**ADC Planning Consultation  
Response from the Historic Buildings Adviser**

| <b>Application Number</b> | A/138/13                                                                                                                     |
| <b>Address</b>            | Site to the rear of The Old House, High Street, Angmering BN16 4AG                                                           |
| <b>Description</b>        | Outline application for the erection of detached dwelling house - This application affects the setting of a Listed Building. |

FRONT
PROPOSED ELEVATIONS
Scale 1:100

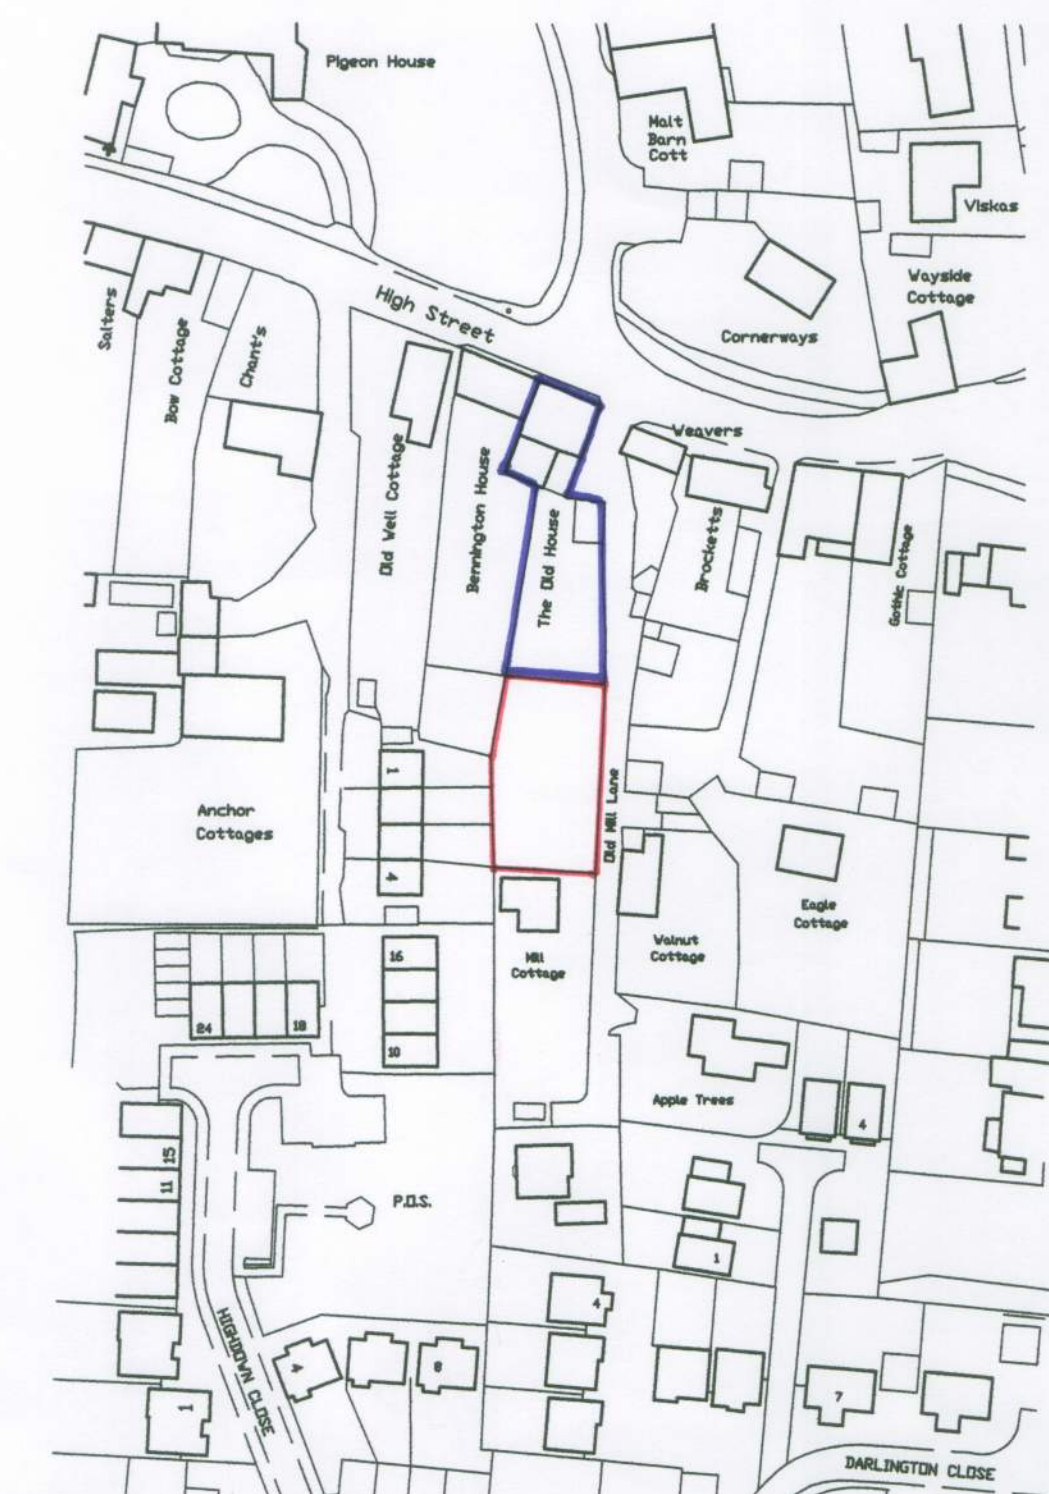
Where the principle of development is considered justified, new buildings should be of a high design quality to mitigate their impact. I am afraid the chalet style bungalow proposed here would not meet this test.
